The Director - Infrastructure Assessments  
Planning Services  
Dept of Planning + Environment  
G.P.O. Box 39  
SYDNEY NSW 2001

Re: Exhibition of State Significant Development Application -  
Stage 3 B of Lismore Base Hospital Redevelopment  
and New Hospital Car Park  
SSD 6848

1 GA - Level 03 3B2
A30001 1:200

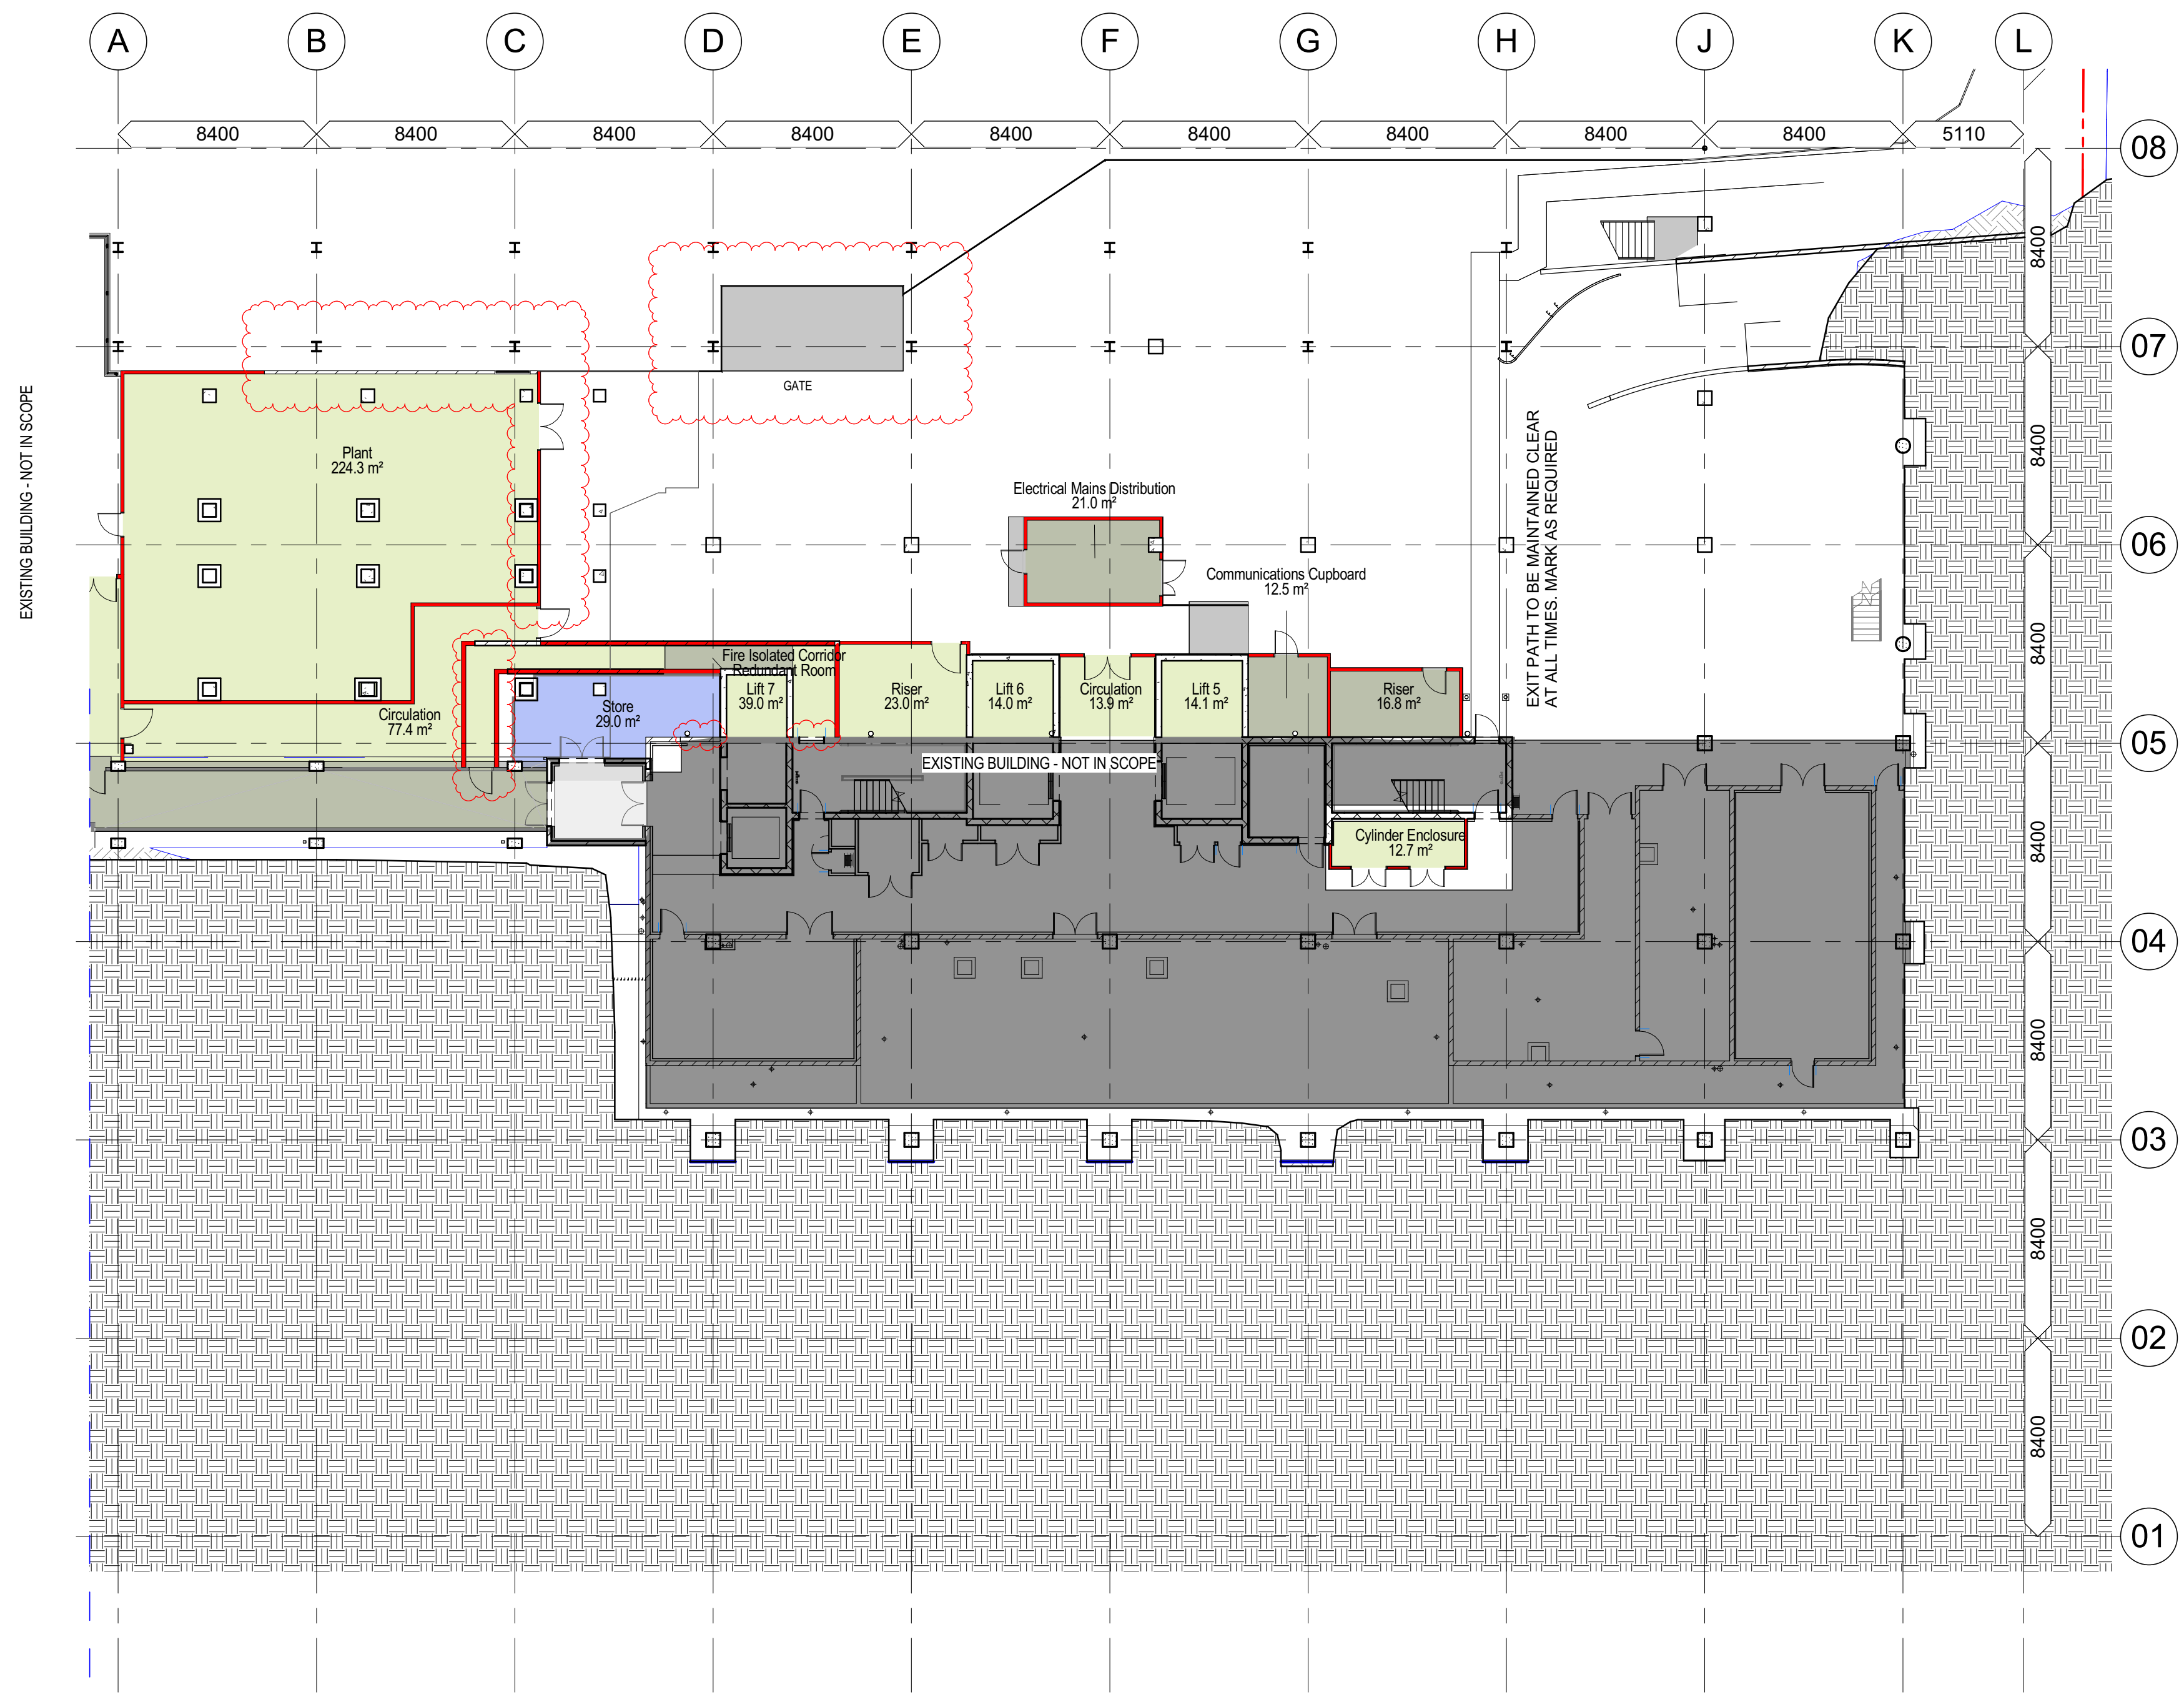
I am the owner and occupier of 7 Little Uvalde St,  
Lismore, which immediately adjoins the northern boundary  
of the proposed delivery vehicle turning bay. Diagrams  
of the retaining wall indicate it would be 1.2 metres above  
the level of the turning bay surface. Discussion reveals this  
may be 1.5 metres.

I request that the wall be heightened to 1.8 metres to  
help reduce vehicle noise and fumes, and to provide  
more adequate privacy screening.
